Culbone
The Leys
Adderbury
Banbury
OXON
OX17 3ES

11 January 2020

Planning Application No. 19/02691/F - 3 new dwellings in The Leys, Adderbury

Client	Mrs Biggam	Project	PROPOSED DEVELOPMENT OF LAND AT THE LEYS ADDERBURY	Drawing	PROPOSED FLOOR PLANS PLOT 2
Architect	Nicholas D Price 45 North Bar Street Banbury OX16 0TH Tel 01295 262952			Scale	1:100
				Date	January 2019
				Drawing No	5392.04 A

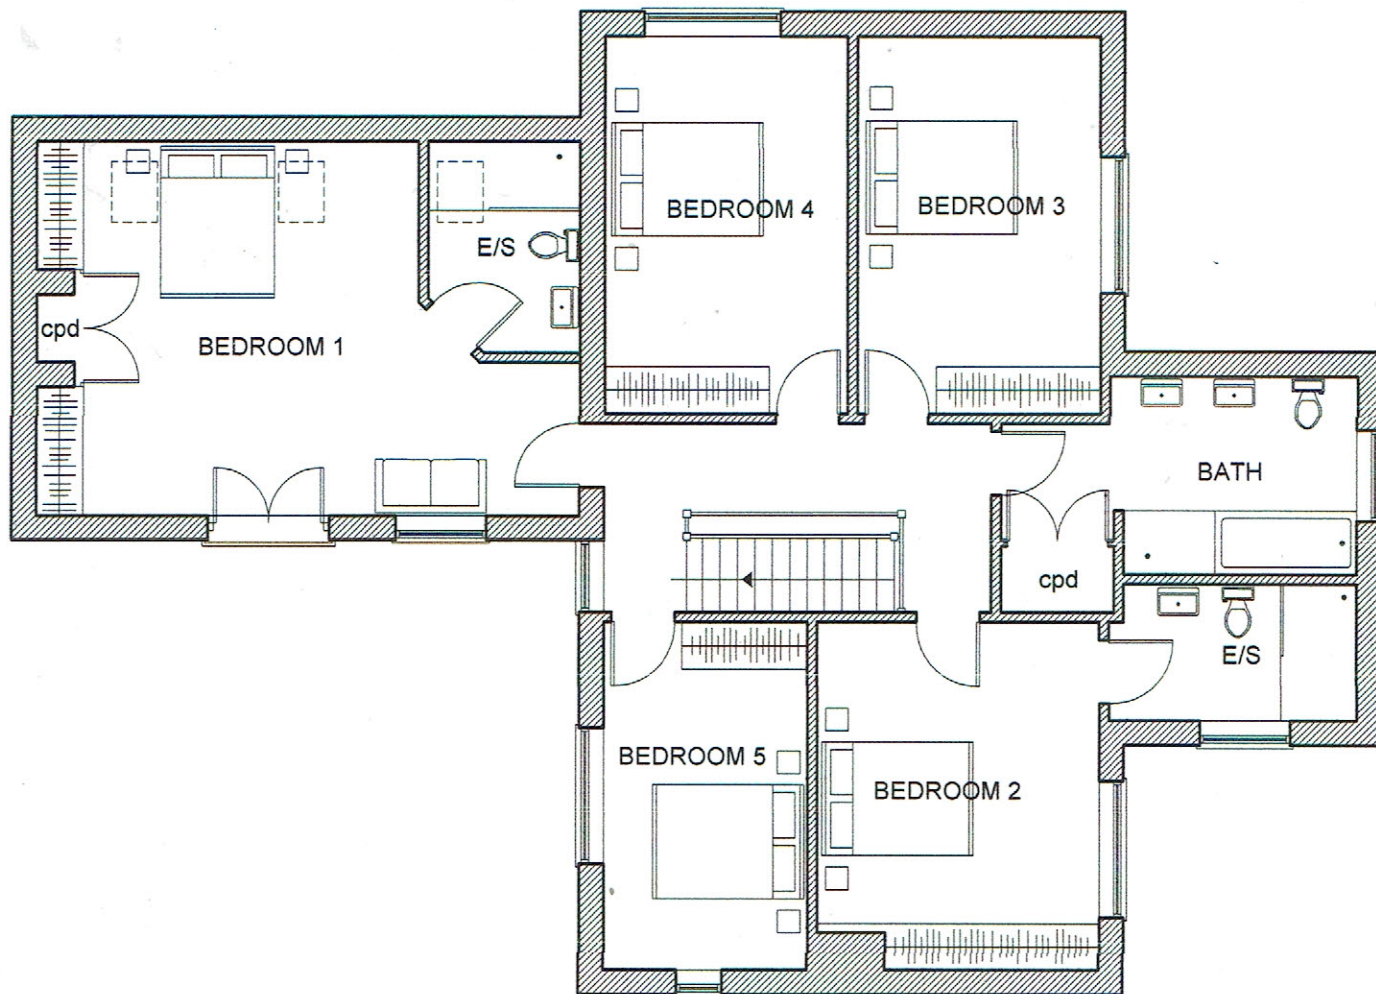
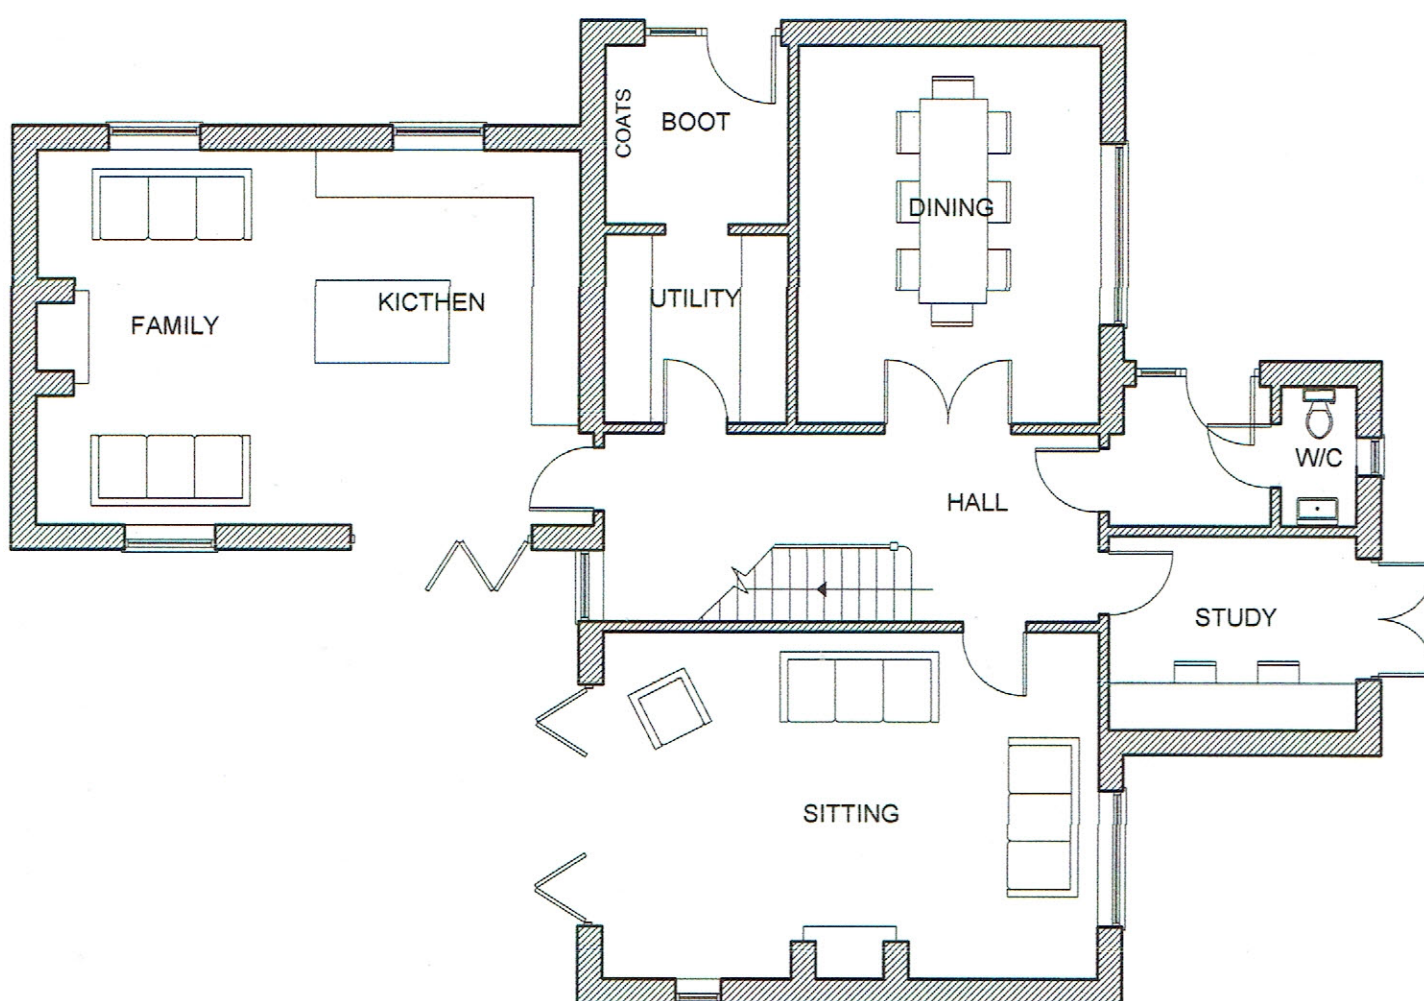
In particular the proposed Plot 2 is a large imposing house only a few metres away from Culbone's boundary fence, directly over looking the garden. On examining the proposed floor plans you have to question the positioning of the windows in bedroom 1. The main windows to this room could surely have been easily put on the front elevation? Also bedroom 5 has a window directly overlooking Culbone's garden, which appears to be a secondary window to this room and therefore for the size of the room completely unnecessary. We see no stipulation in the plans for Bedroom 2 's en-suite window to be frosted? Hence not only are all of these windows extremely intrusive on Culbone's garden areas but we find it hard to imagine the sort of person buying this size and price of house - actually wanting to look out on sheds, stables, chicken house and an old greenhouse!

Planners and developers also need to fully appreciate that the proposed development site is on a gradient and as such, means that Culbone will be directly looking down into Plot 2. Not only is this unfavourable to Culbone, surely it would also create a privacy issue for any occupants of the proposed new house (Plot 2)?
